I believe you are the case officer for the One Stop application (AW/237/19/PL) at the former Ship Inn in Aldwick Street?

From: Roger Beam [REDACTED]
Sent: 21 November 2019 09:14
To: Cllr. Tony Dixon [REDACTED]
Subject: Ship Inn tracking deliveries

I did some detailed reading of the correspondence on AW/237/19/PL and there is much to be alarmed and concerned about how this has been assessed by WSCC Highways.

Drawing No:
B 102

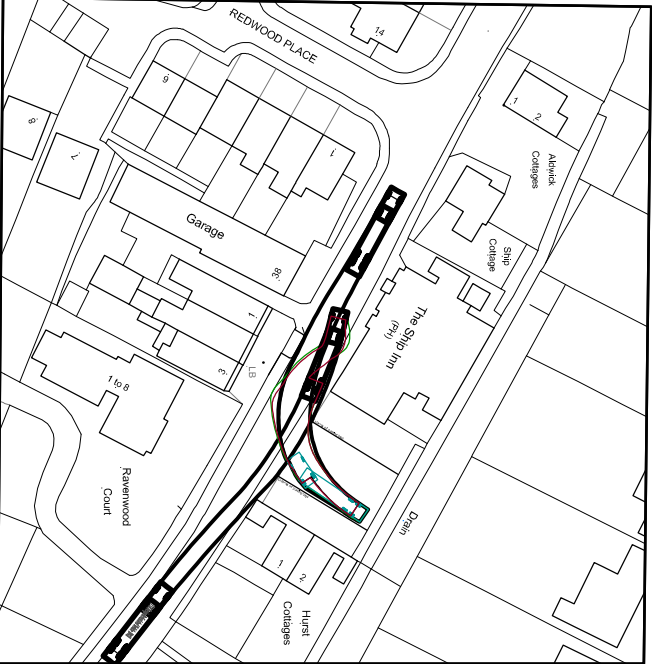
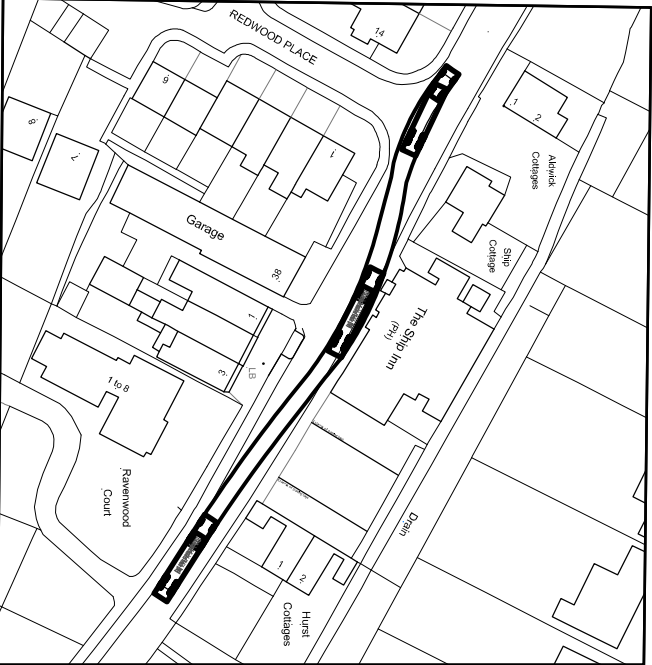
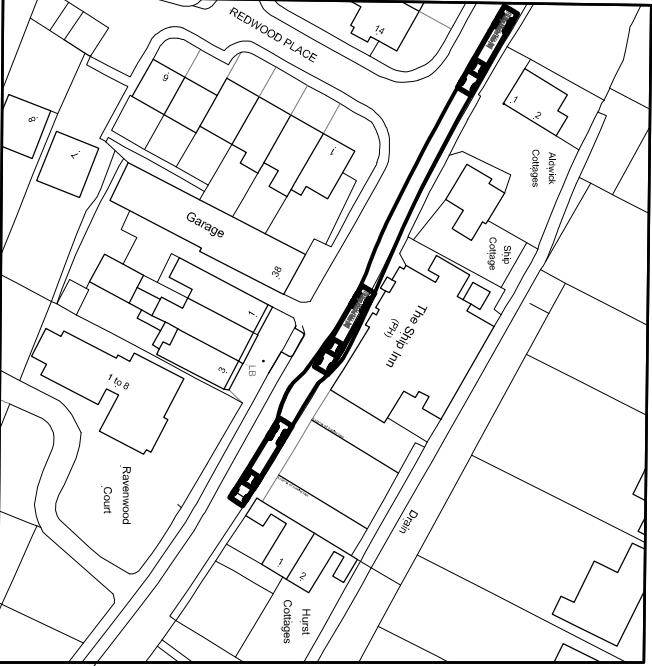
There are vehicle tracking plans supplied to show how unloading would take place. The preferred option is for the 38 foot articulated lorries and rigid vehicles to back in to the car park. Plans dated 30 September and 3 October show the vehicles approaching from the east and crossing the central line to manoeuvre a reversal into the Ship Inn car park. The vehicles almost reach Redwood Place and then use the whole road to back up and turn in.

Alternatively, these vehicles may not go into the car park at all but pull up by the side of the pub building. Approaching from the east, they once again cross the central line and then park up as close as possible by the porch and the bay windows. One Stop allow for 30 minutes unloading and yet WSCC Highways on 9 October appear to think it will be a tight fit but traffic will still be able to get by. This is supported by a crude drawing submitted 3 October by One Stop which purports to show traffic coming from the west swerving into the middle of the road to avoid a parked HGV while traffic from the east is able to flow without obstruction. This does not make any sense.
